Re: PA23-005 – Creekside PRD – Technical Review 1
7808 40th Street, 7811 & 7715 40th Street NE, APNs 29050200100200,
29050200100300, and 29050200100400

BINDING SITE PLAN / PLANNED RESIDENTIAL DEVELOPMENT COMMENTS

**HORIZON VIEW HOLDINGS, INC.**  
**CREEKSIDE**  
 PRELIMINARY WATER AND SEWER PLAN

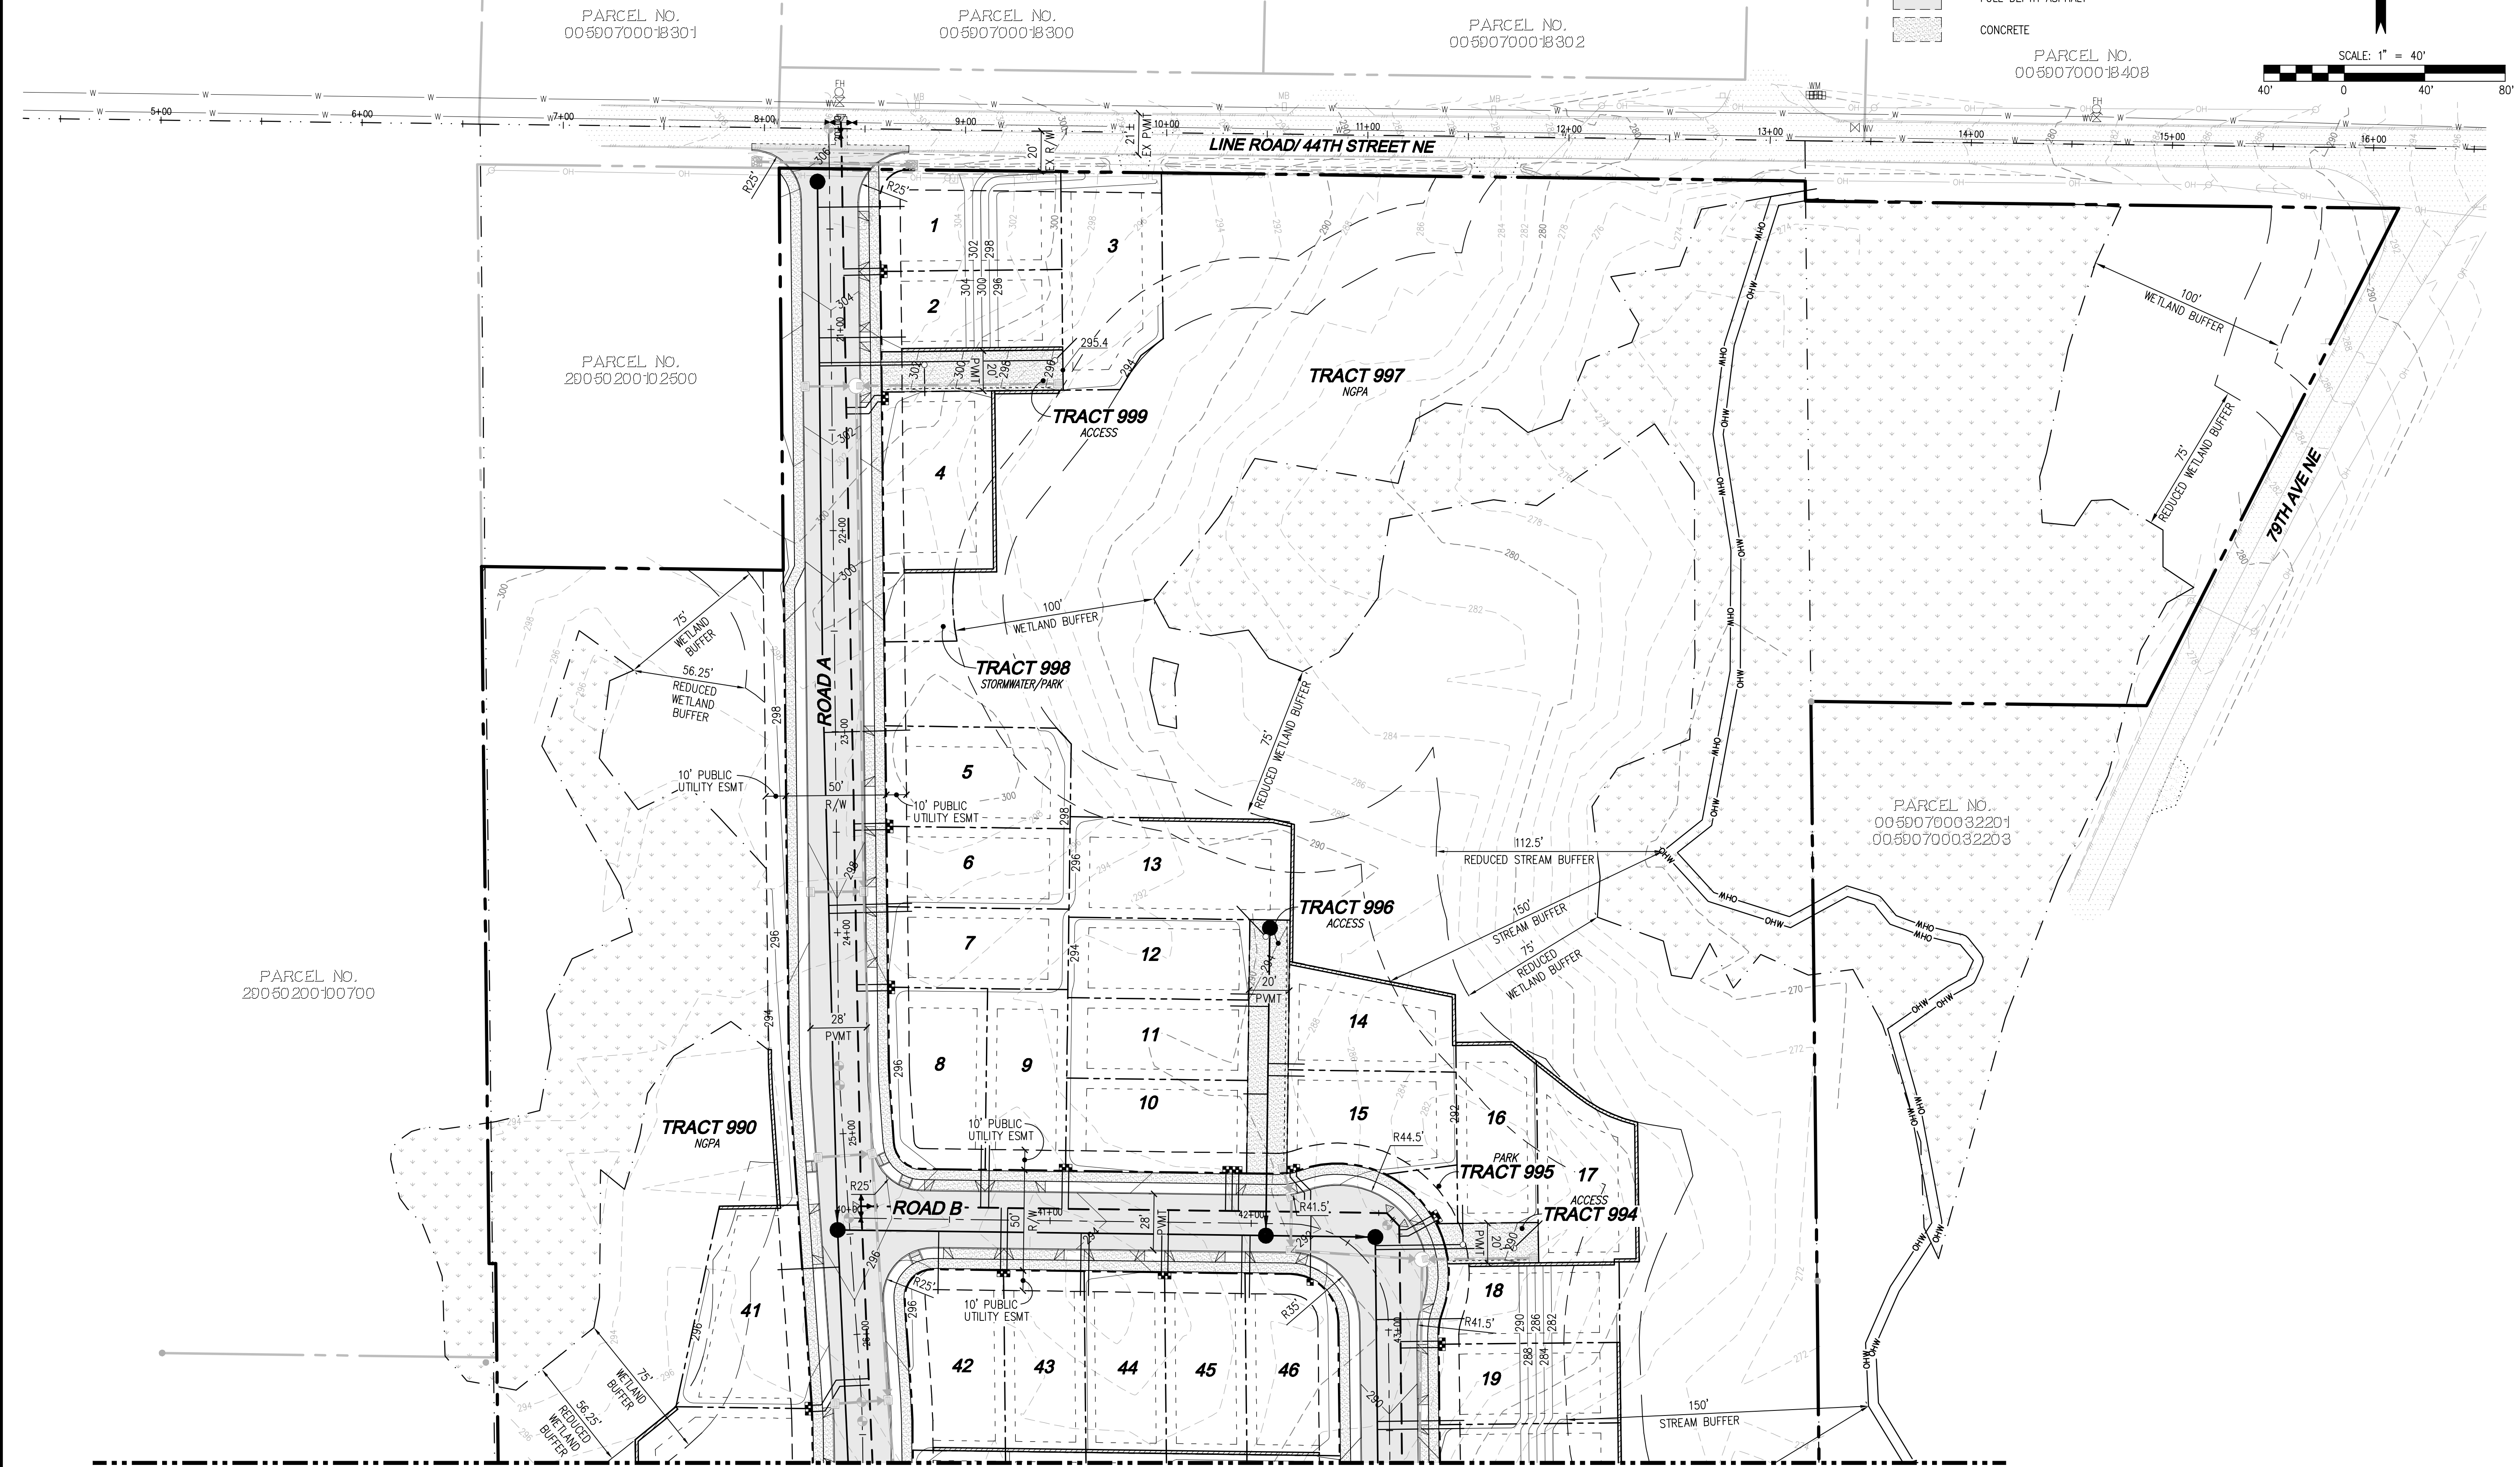
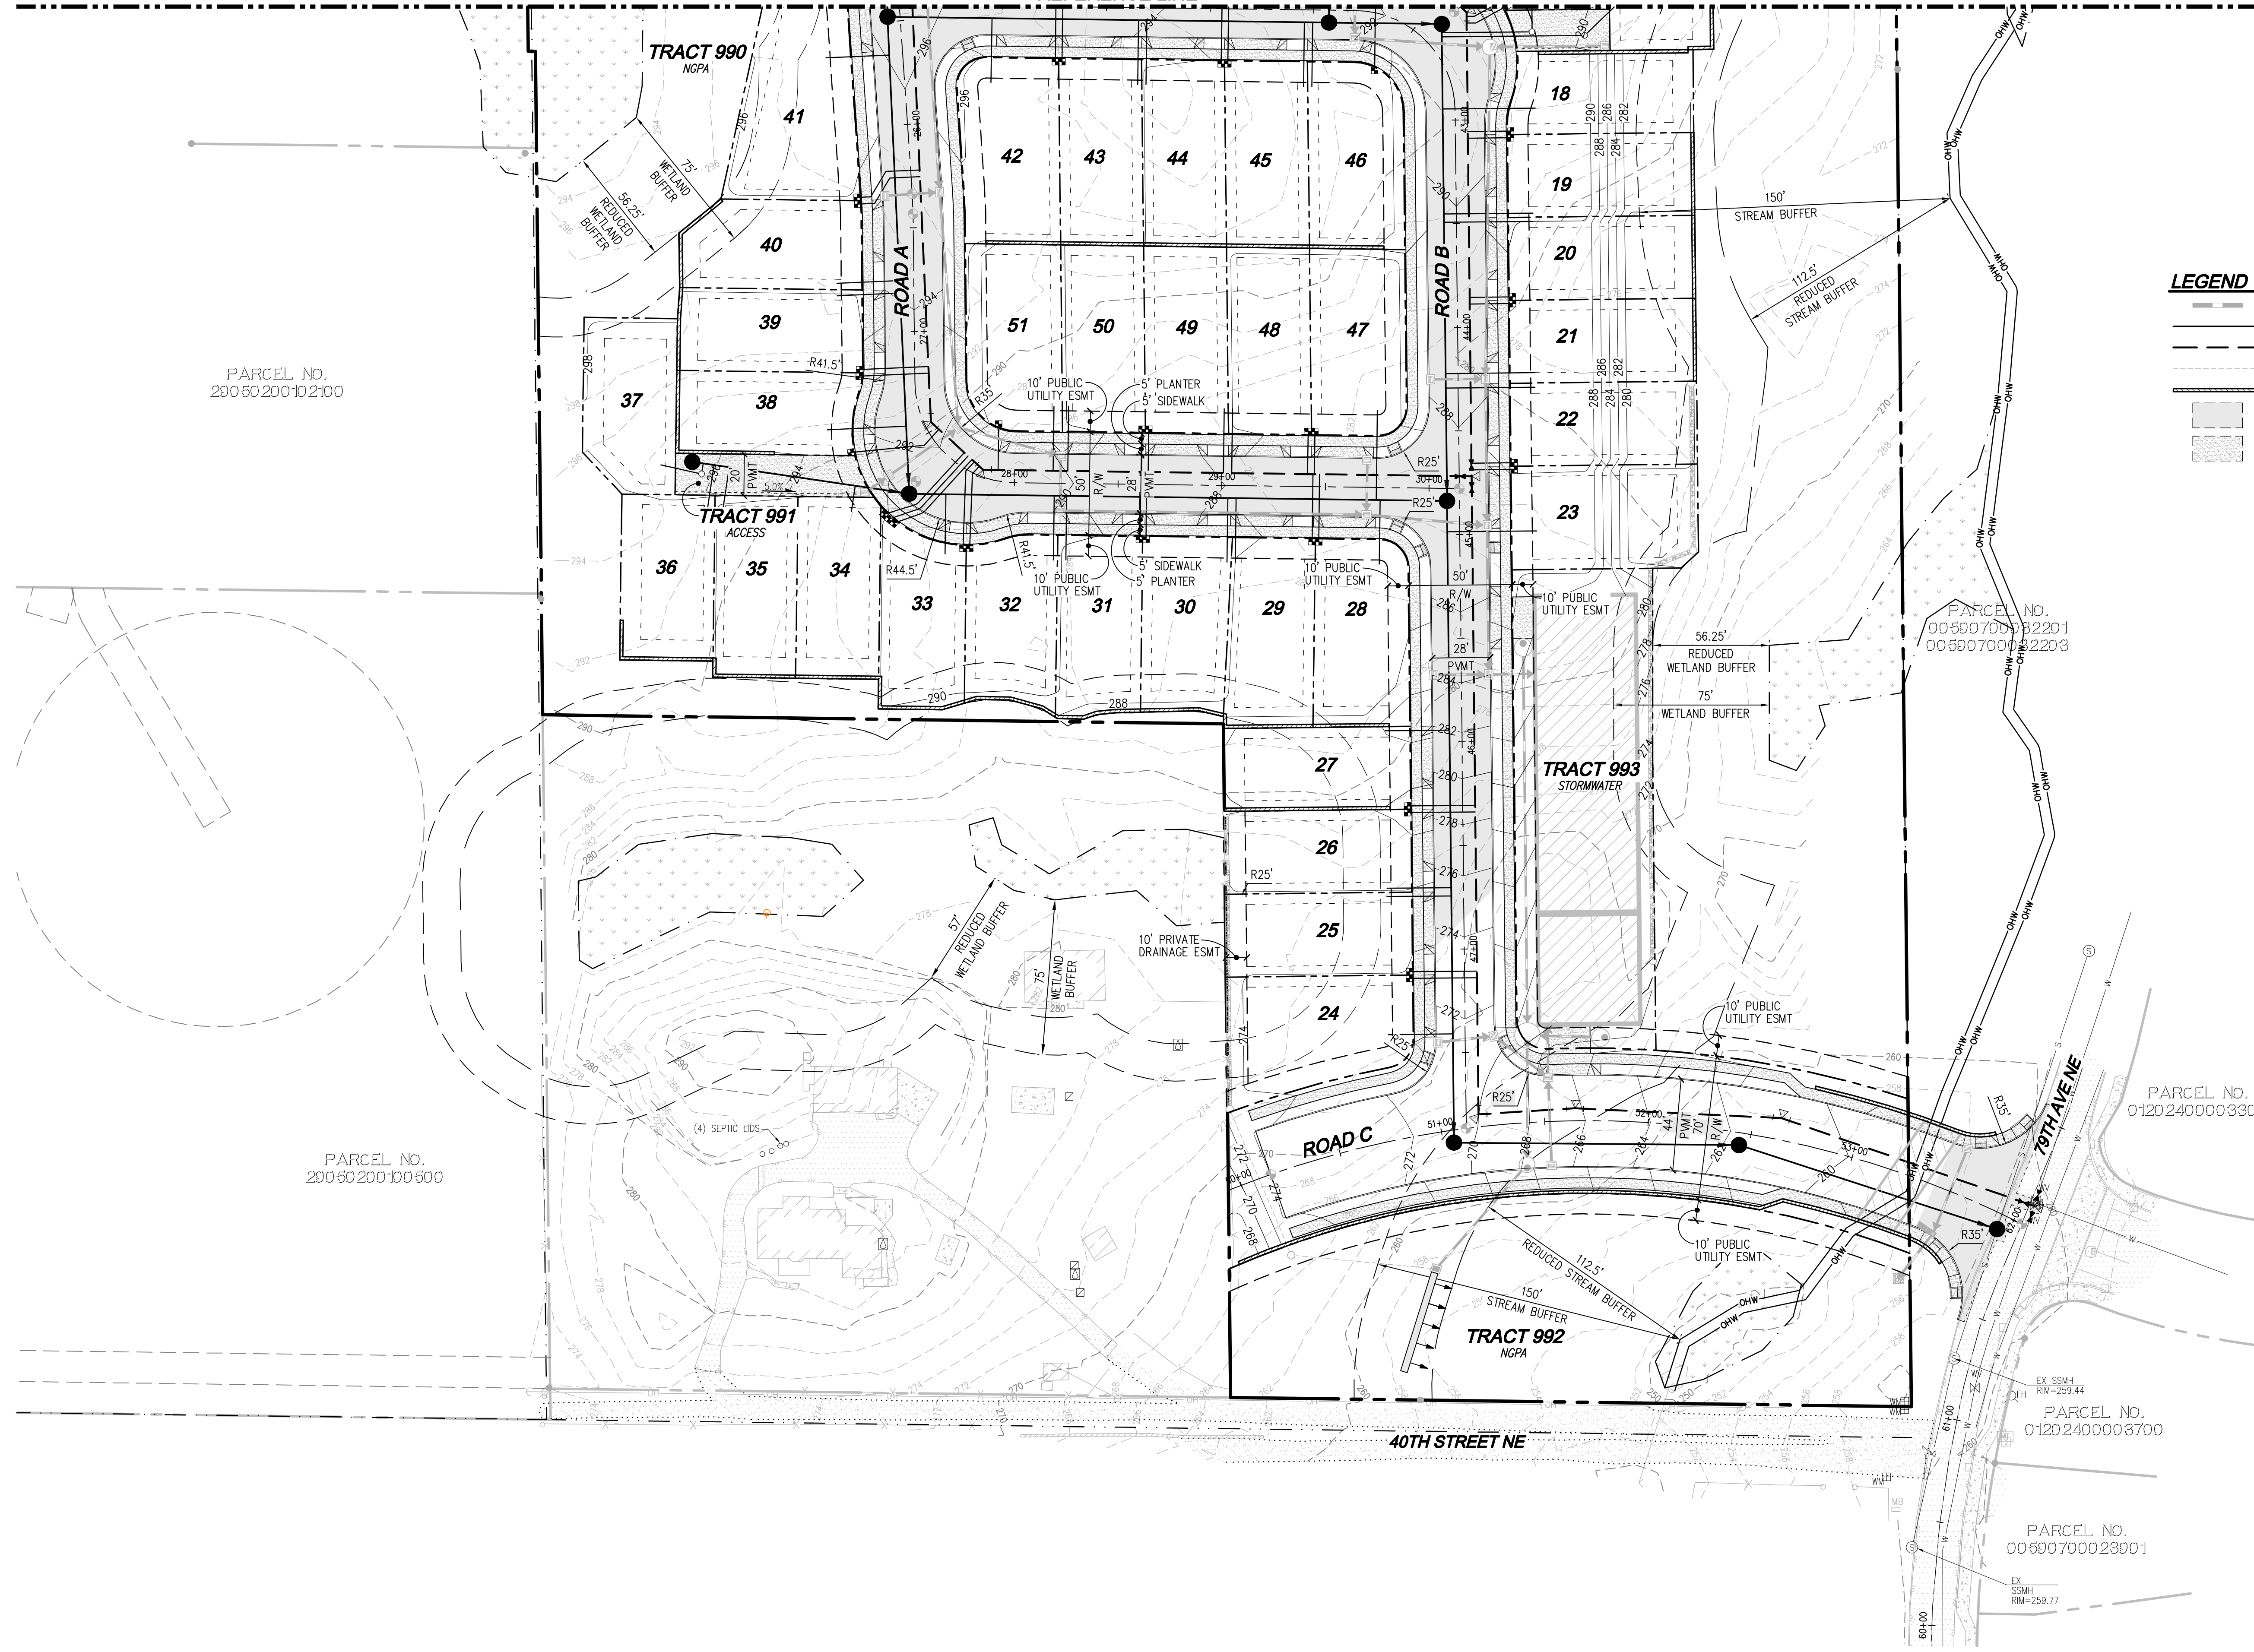
10. Sewer in 79th Avenue is a dry line. In order for sewer to become 'live' for this project, sewer shall be connected to the west, across APN [01195800099700](#). See comments from Kacey Simon, Civil Plan Reviewer, for further detail. There will likely be critical area impacts related to this extension. Please provide an updated critical areas report and mitigation plan for these impacts.

11. Sewer will need to be extended along 44th Street and 79th Avenue where they have frontage. These extensions are not shown on preliminary construction plans. These extensions will likely have critical area impacts. Please provide an updated critical areas report and mitigation plan for these impacts.

- b. Storm will need to be installed along the projects frontage.
 - c. Sewer will need to be extending to the east along 44th St NE to the intersection of 79th Ave NE.

- d. Since you are proposing connecting to a dry line, please show how you will be connecting the dry line to live sewer? The connection will need to be made at the intersection of 79th Ave NE and 34th PL NE and run to the west through the Autumn Vista HOA property to the manhole located on 34th PL NE in the Creekwood Neighborhood.
